DRB CASE ACTION LOG - BLUE SHEET

Project #: 1002471

Application #: 13DRB-70457

Project Name: Land of Estate

OWNERS(S): JOHN & DOLORES LIND  
RECORDED DOCUMENT(S): DEED: DOC. NO. 2001035649  
SECTION, TOWNSHIP, RANGE: SEC.24, T.10N., R.2E., N.M.P.M.  
SUBDIVISION(S):  
PROJECT No. LIND-2012 Sheet 2 of 2

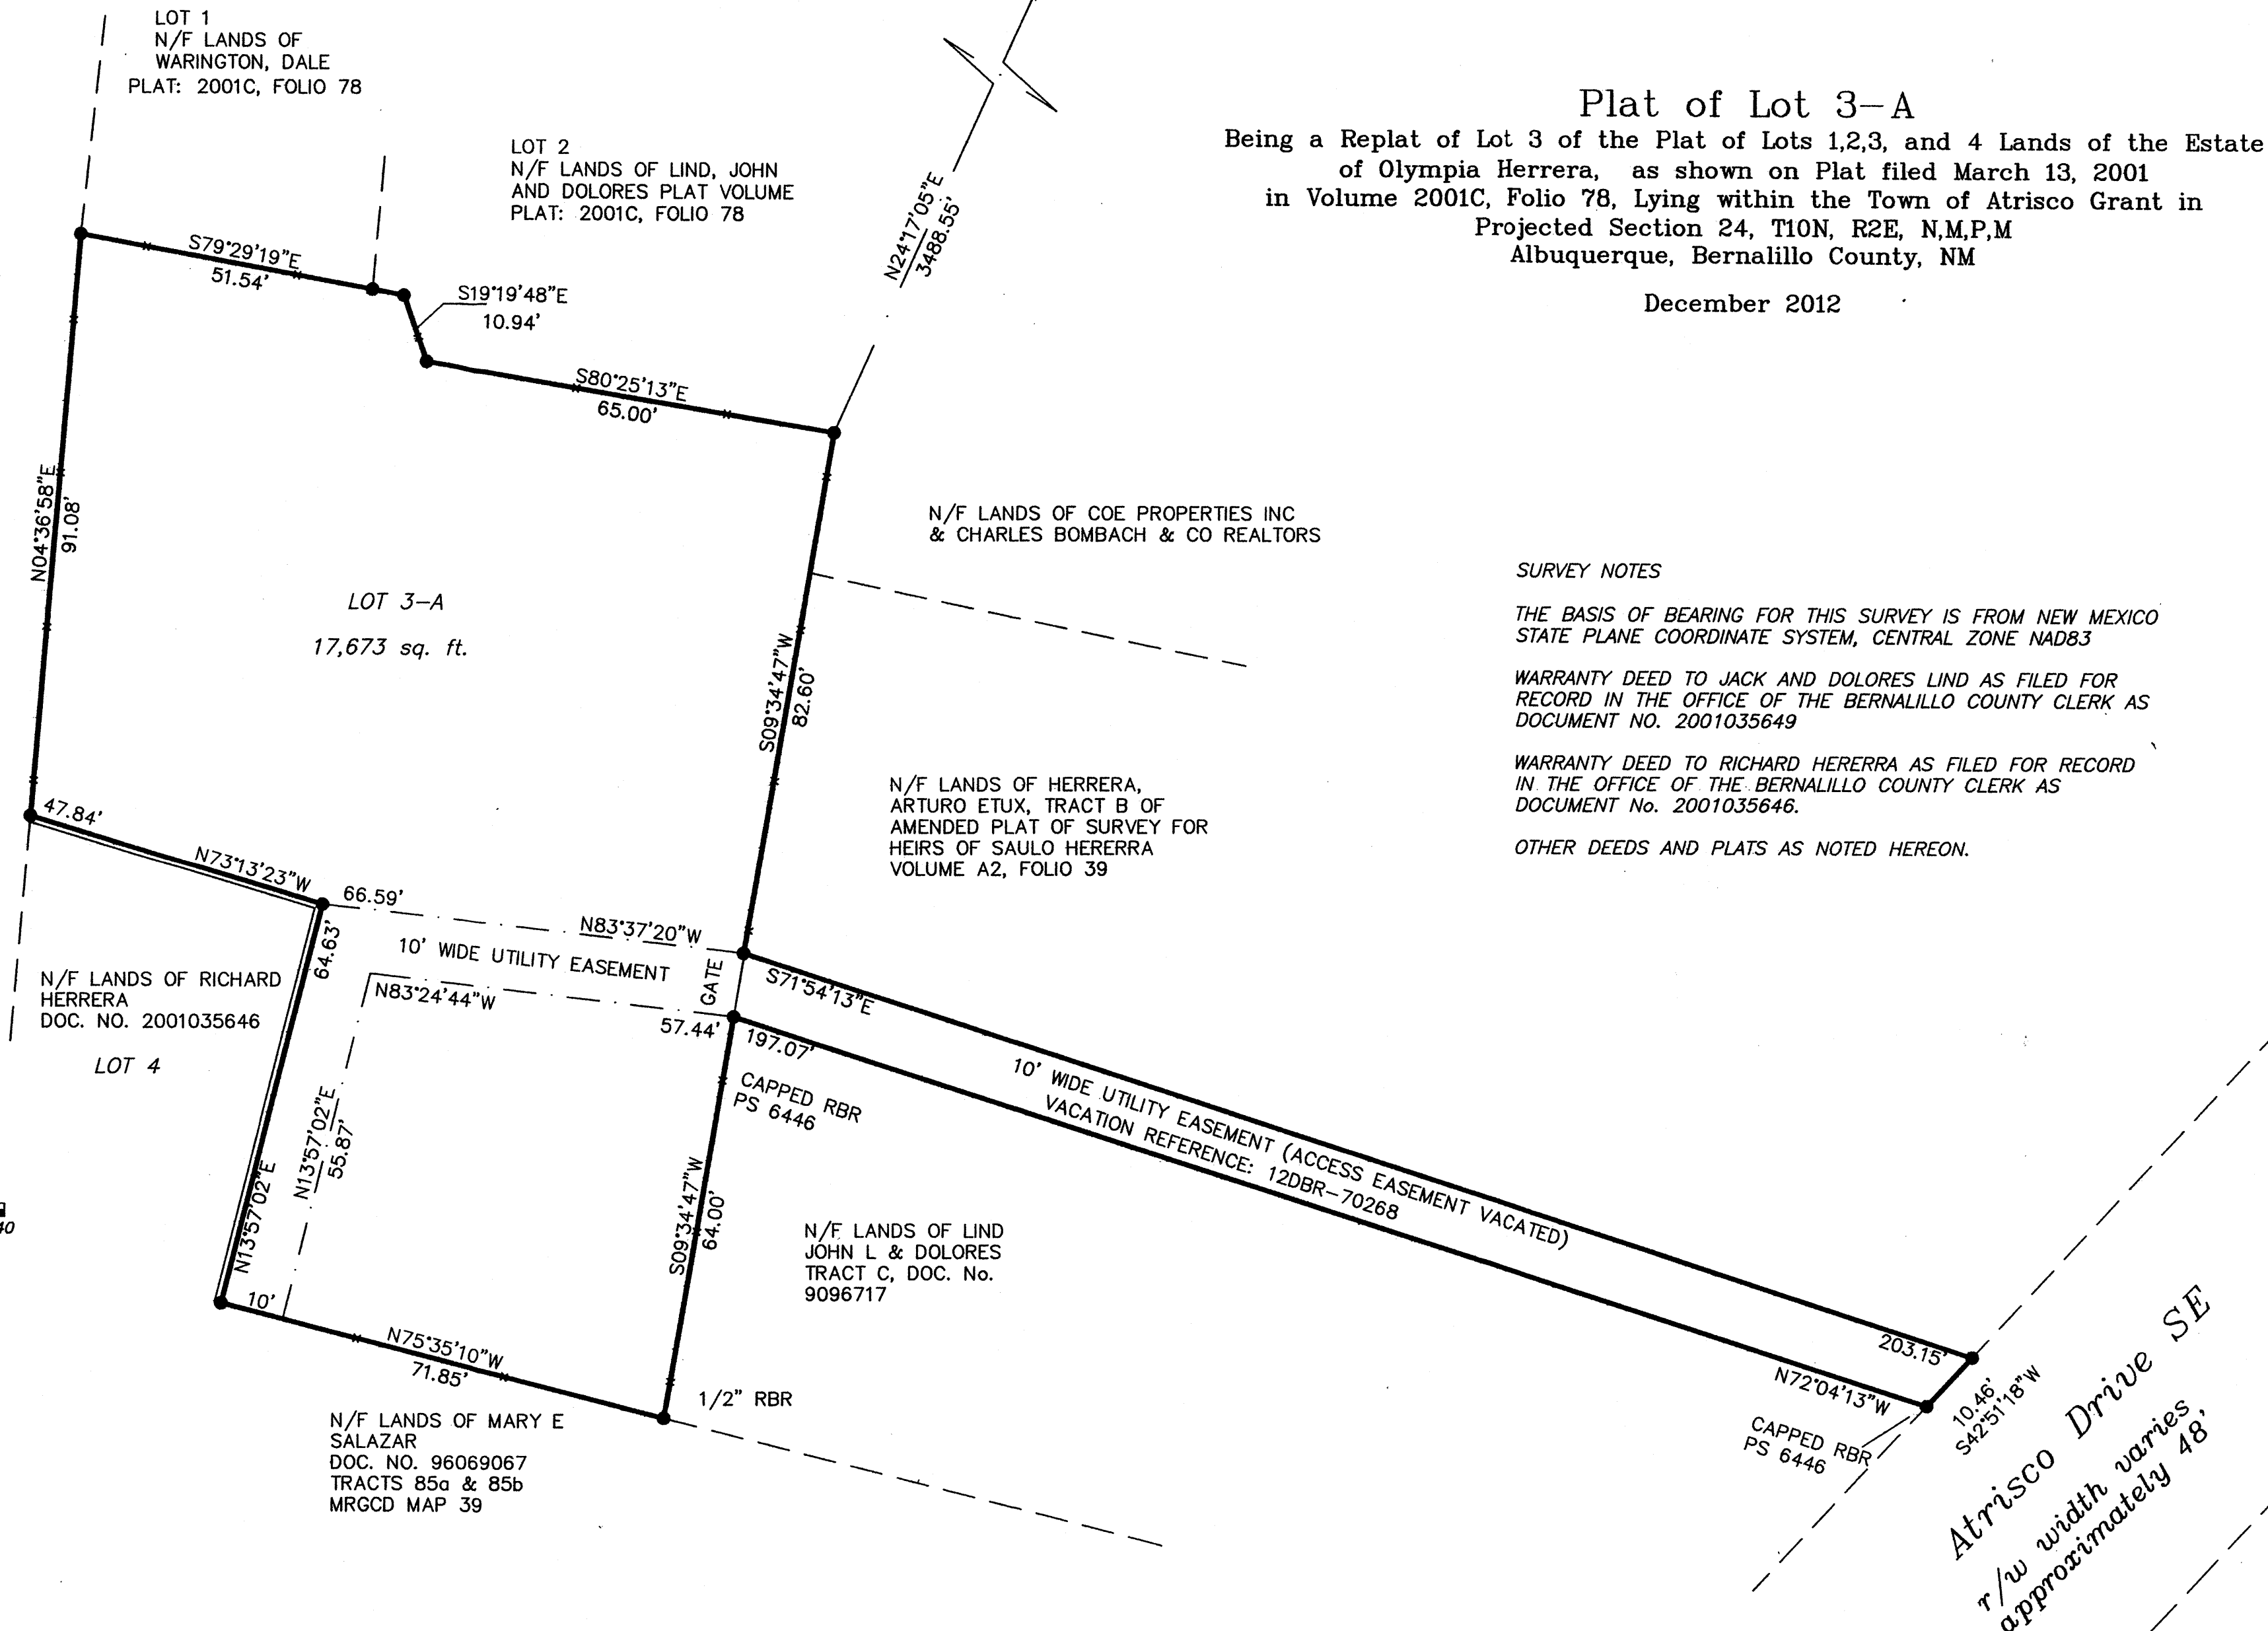
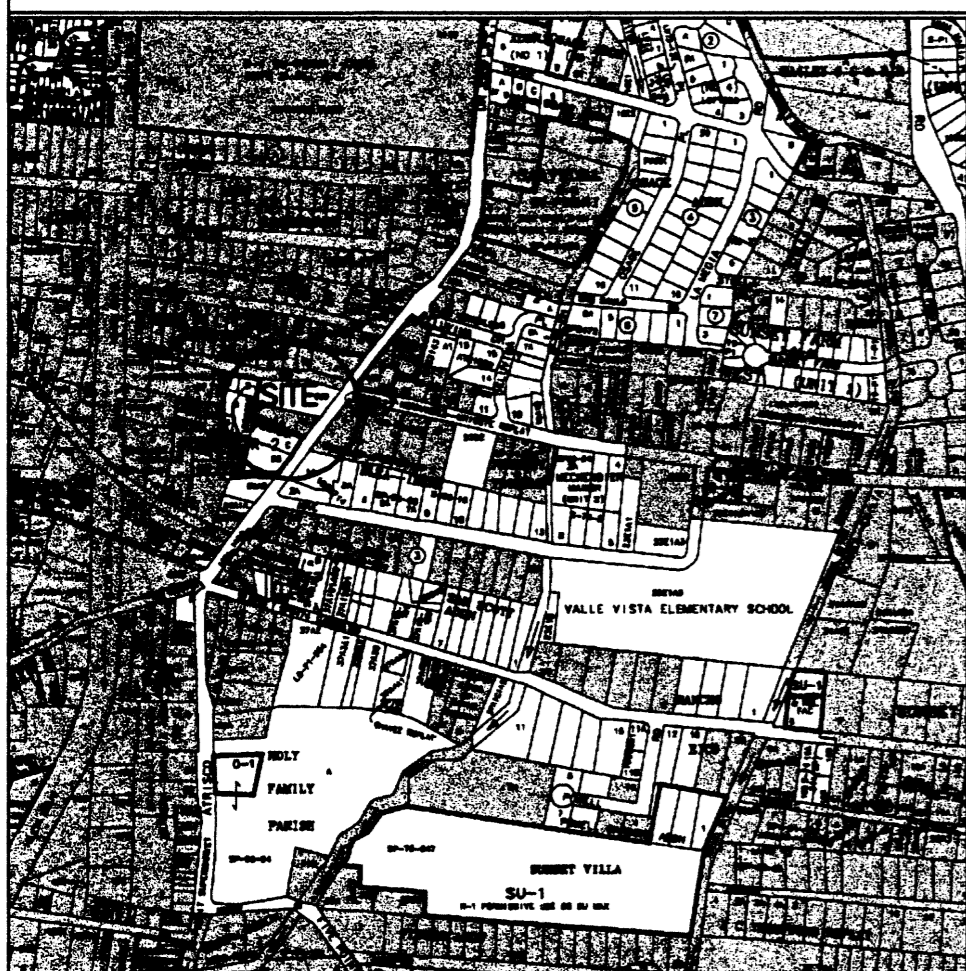
PLANNING (Last to sign): reference vacation 12DRB-70268 on sheet 2, dxt

PARKS / CIP: revise signature line
